Recommendation Report for Planning Permission for Works or Extension to a Dwelling

REF NO: EP/34/22/HH

LOCATION: 111 North Lane
East Preston
BN16 1HB

PROPOSAL: Two storey side/rear extension.

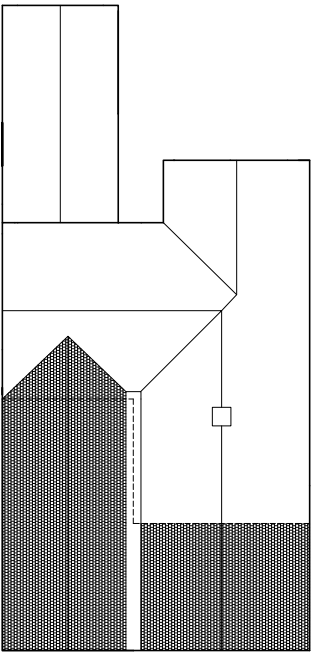
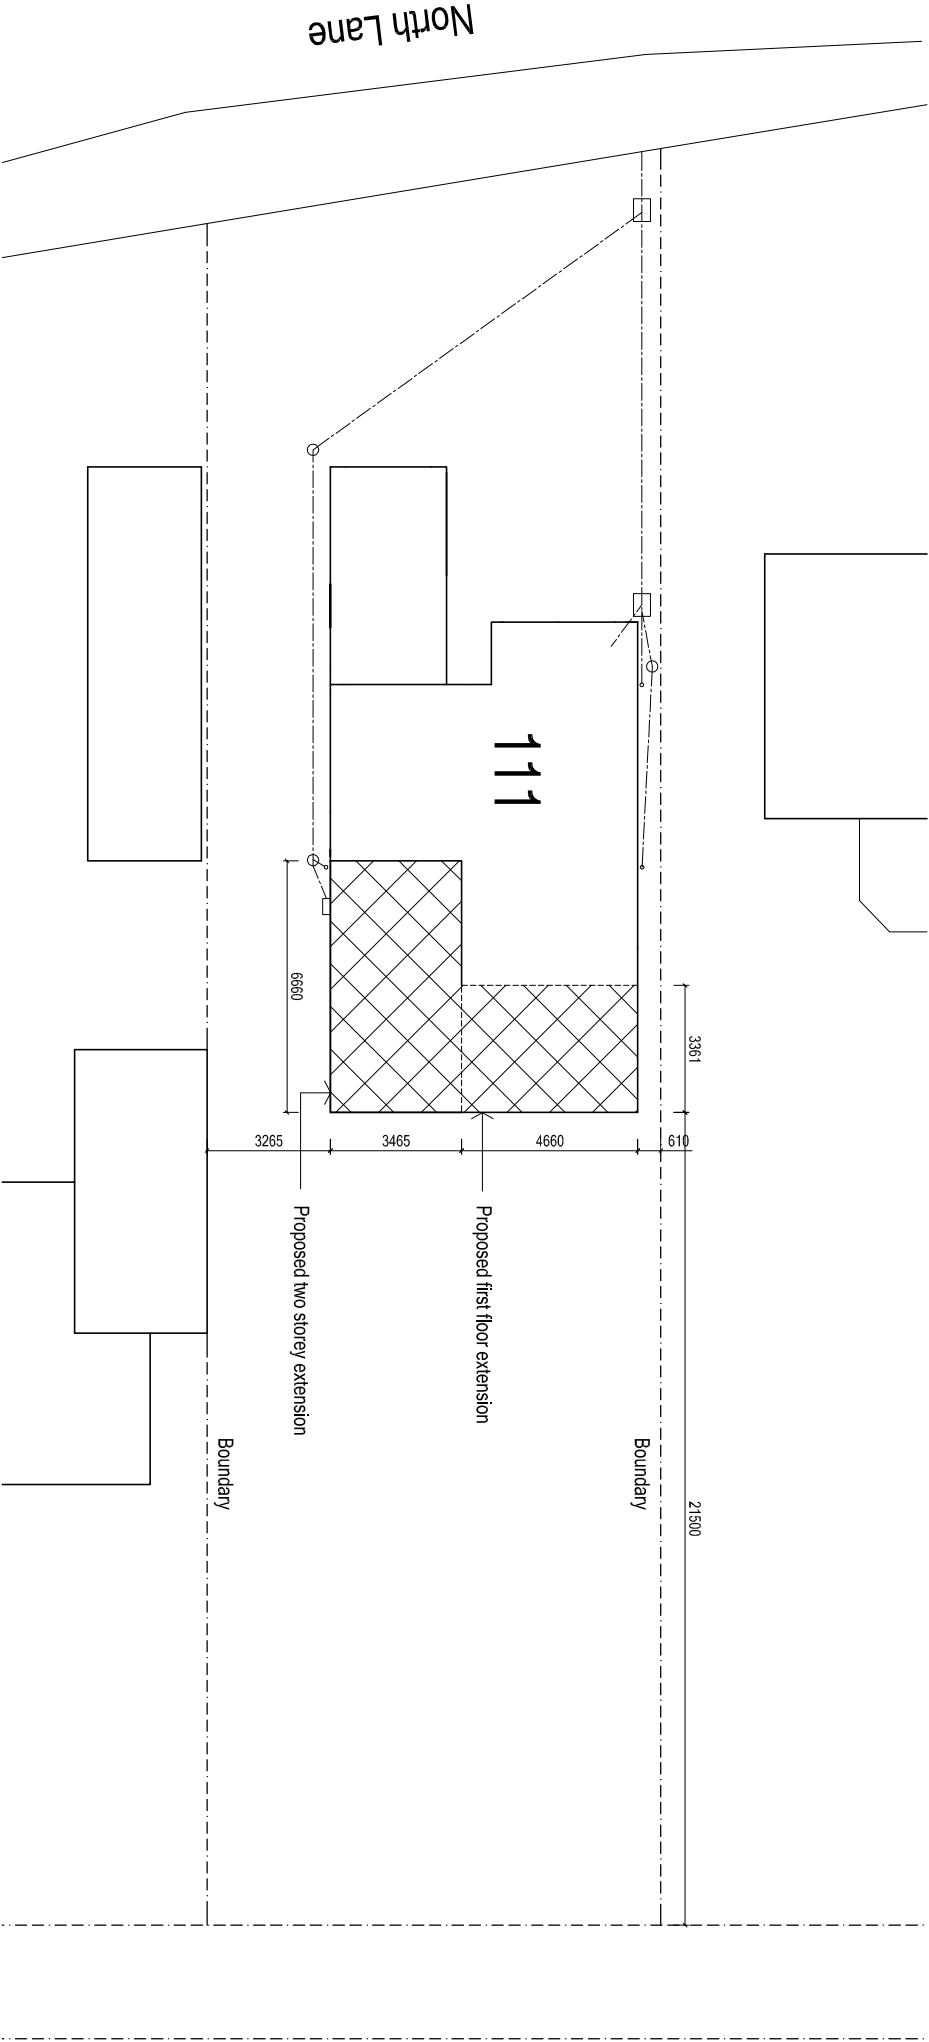
The proposed development will have an impact upon the residential amenities of neighbouring dwellings. The proposed extension would not protrude past the side elevations, and it would be located 3.2m from the western boundary, 21.5m from the southern boundary and 610mm from the eastern boundary. Due to the irregular spatial composition of the properties in this location, the property to the east is located further forward on its plot, the property to the west sits behind on its plot and therefore the proposed host dwelling intersects the 45-degree disallowed area for rear extensions with the property to the east (No. 109). The 45-degree rule forms part of Design Guidance so that rear extensions to detached dwellings

PROPOSED FIRST FLOOR PLAN 1:100

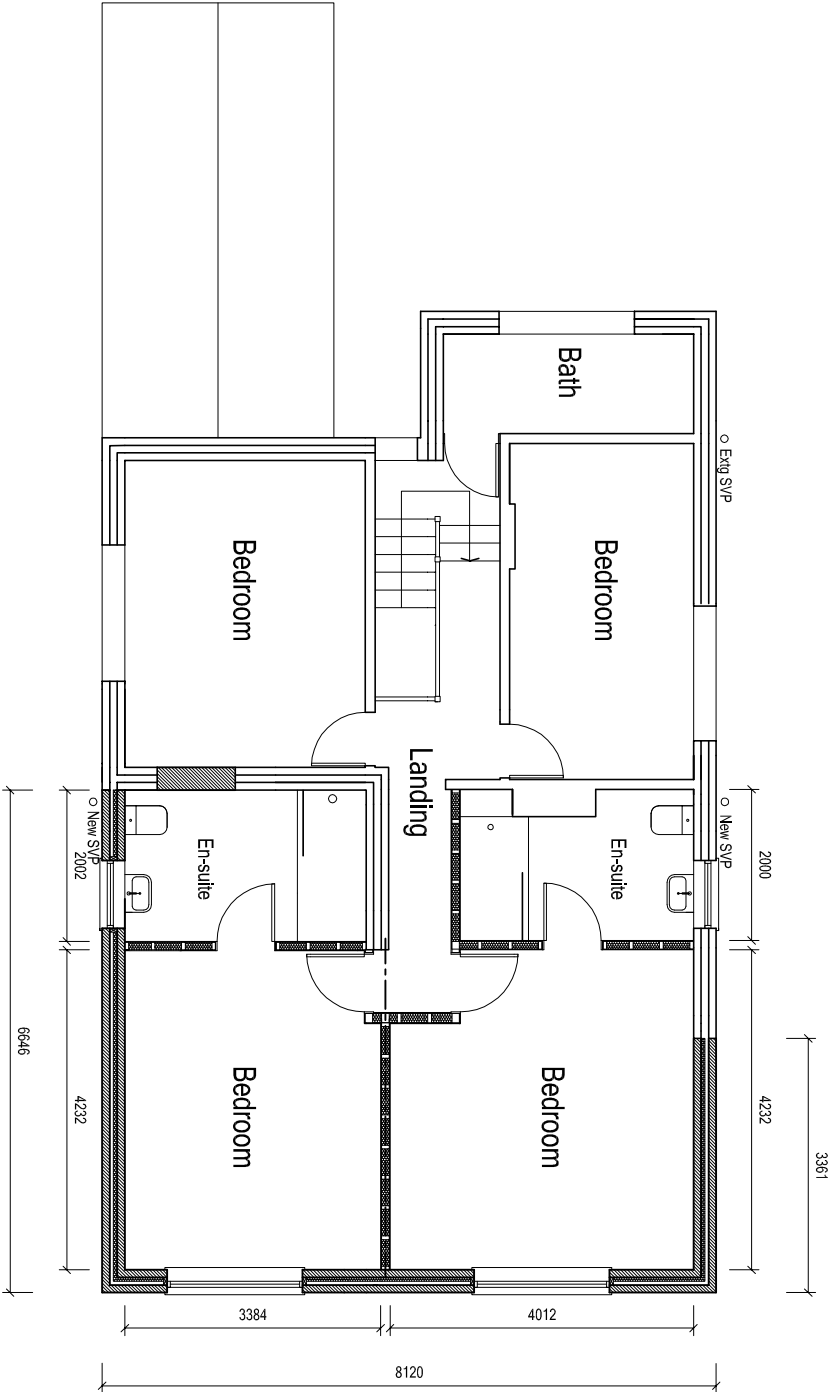
The proposed windows located to the southern elevation at first floor level will have an acute viewing angle towards the neighbours first floor windows by reason that the rear elevation of the host dwelling and the front elevation of the property to the west are almost in line with each other. There is a proposed bathroom window to the first-floor western elevation, this will be obscure glazed. All other proposed windows will be to ground floor level, where it is generally accepted that overlooking does not pose an issue. The proposal does not therefore gain any significant views of any neighbouring dwellings.

ARW Design	DRAWING TITLE: PROPOSED ELEVATIONS PROJECT: TWO STOREY REAR EXTENSION & ASSOCIATED INTERNAL ALTERATIONS	LOCATION: 111, NORTH LANE, EAST PRESTON CLIENT: E. HOBSON	SCALE: AS NOTED @ paper size A3 DATE: FEB 2022	DRAWING NO: 6047/3
ARW Design

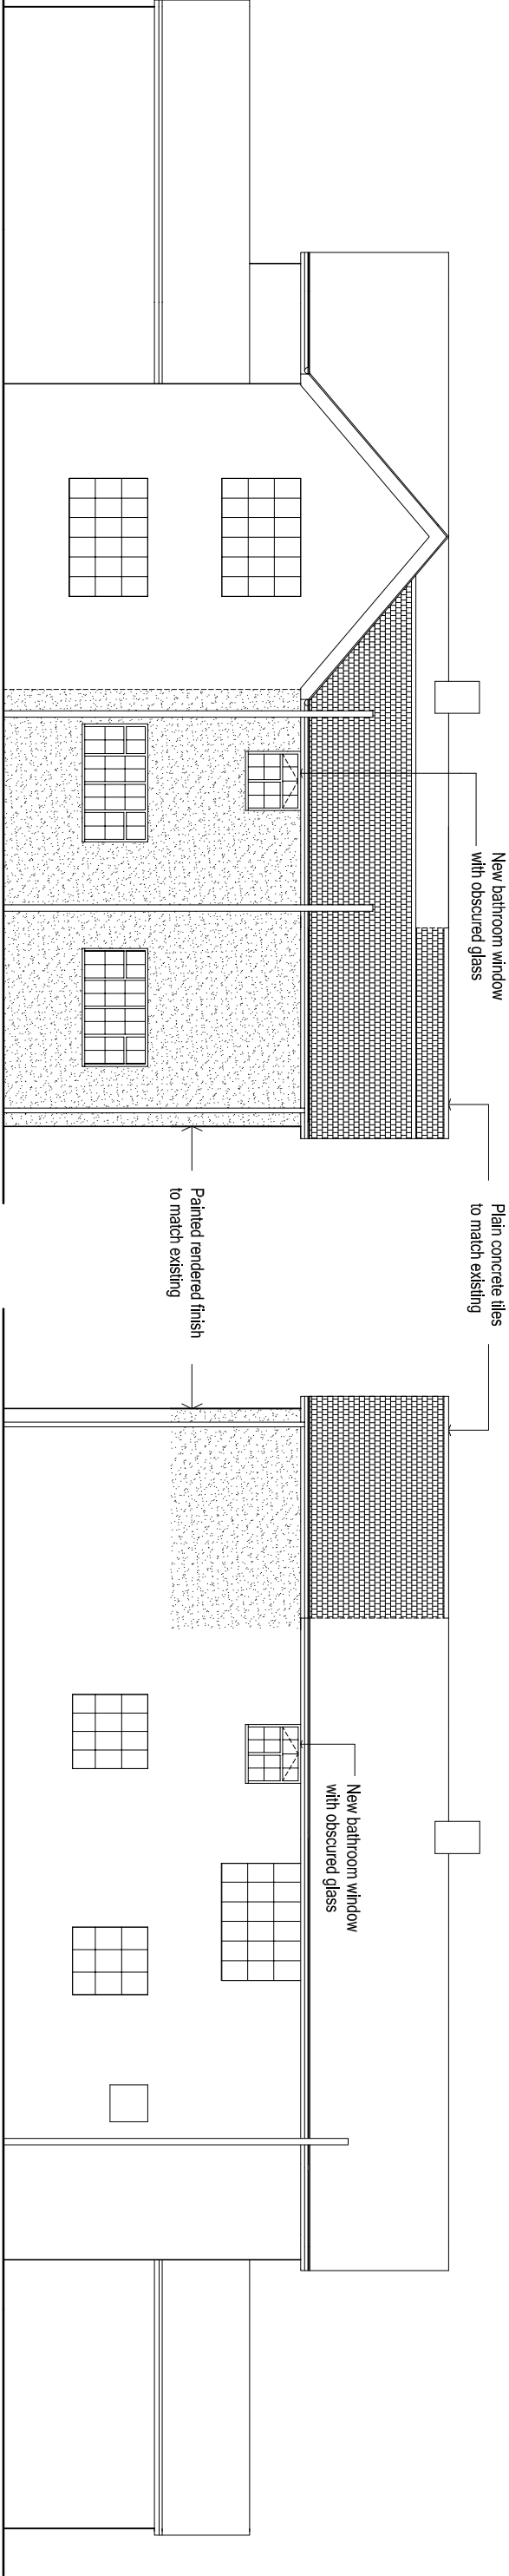
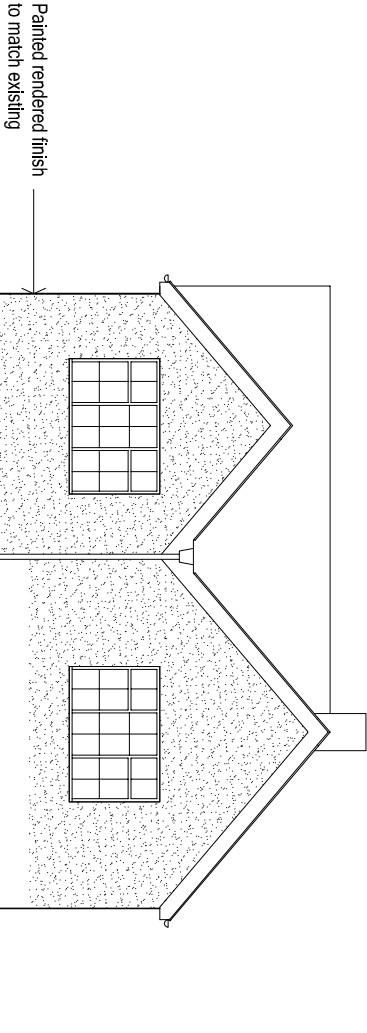
It is proposed to extend to the rear of the host dwelling at its deepest part the extension will protrude out by 6.6m, it will run the full width of the building and the proposal encompasses an existing flat roof single storey extension. The proposal will extend to form a double gable end to the southern elevation. The host dwelling is situated on a good-sized plot which is comparable to others on the southern side of north lane. There is an irregular building line and no prominent character to the buildings in the locality.

The rear extension, by virtue of its location will not impact on the street scene and the proposal will not have a detrimental impact on the established spatial pattern, or visual amenity of the area. The proposal is subservient in term of appearance and scale by reason that the proposed two gable ends are of equal and lower heights to that of the main roof, and it will have an eaves line which continues through from the existing level. The proposal is sympathetic in style to the host dwelling due to the proposed materials and modest, largely open scale of the development.

do not adversely affect privacy or cause harm through overshadowing. No side facing windows are present to the east elevation. It is acknowledged that the host dwelling will already overshadow the rear elevation of No.109 to the east and the increase length of the first floor at this point will increase this effect to an unacceptable degree. As such, the proposal conflicts with design guidance in that the accumulative increase of overshadowing to No 109 in the later afternoon periods will cause harm to the amenity of the occupiers of that property.
